Application No: K/13/21/HH

Site Address: York Lodge Brookside Road East Preston BN16 1SE

Description of works: Proposed first floor extension above existing ground floor rear extension with new barn hip to gable to north elevation to replace existing full hip. Extension to first floor loft to include new flat roof dormer to rear roof slope and minor alterations to front west dormer and the addition of rooflights to north, south, west elevations.

21/4798/8

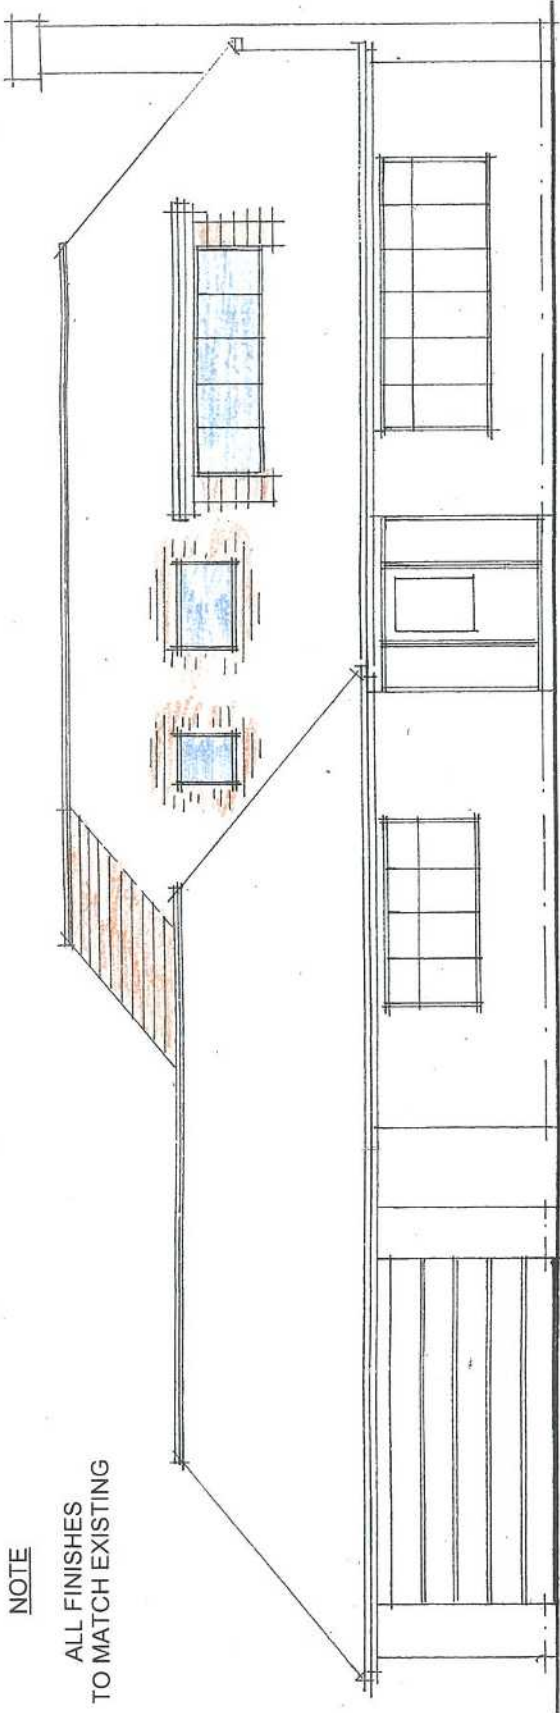
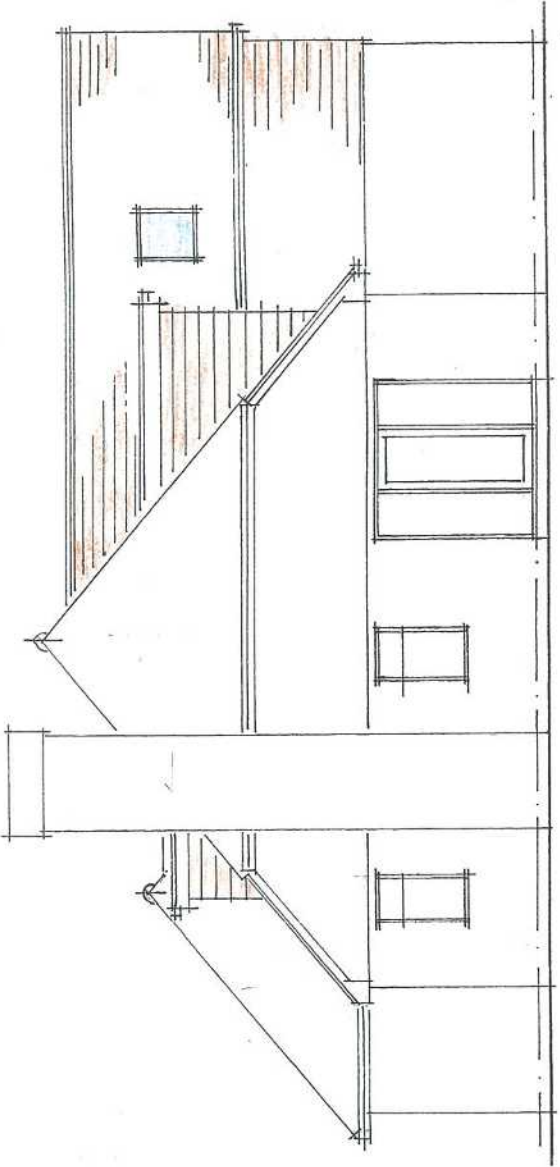
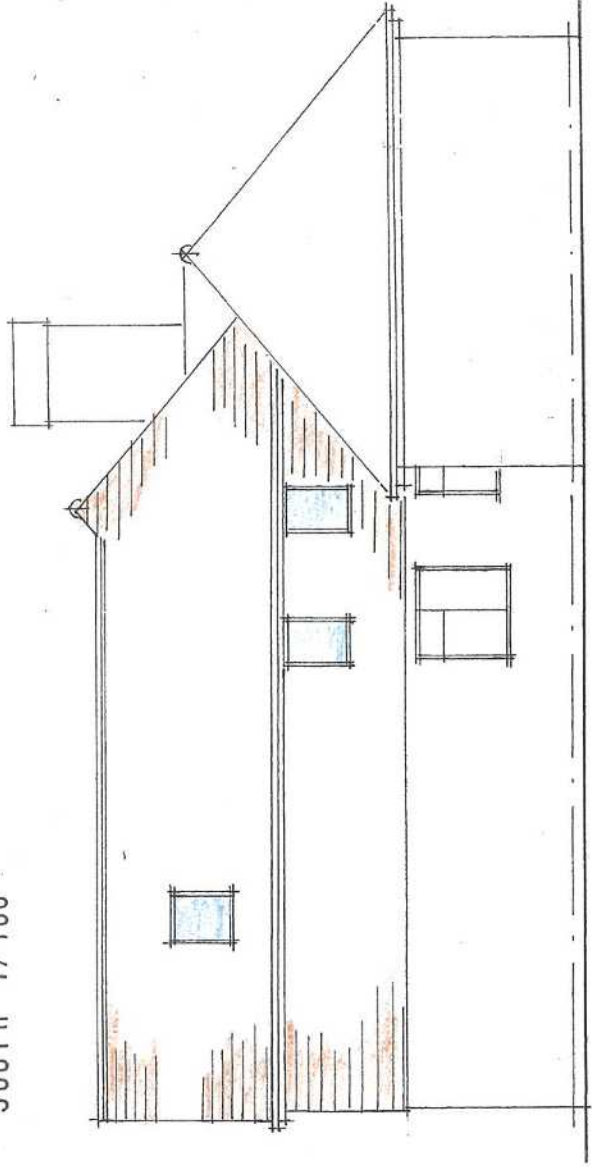
Council has no objection subject to the case officer being satisfied there is no overlooking of neighbouring properties and no undue light pollution from the roof lights at night (dark skies policy)
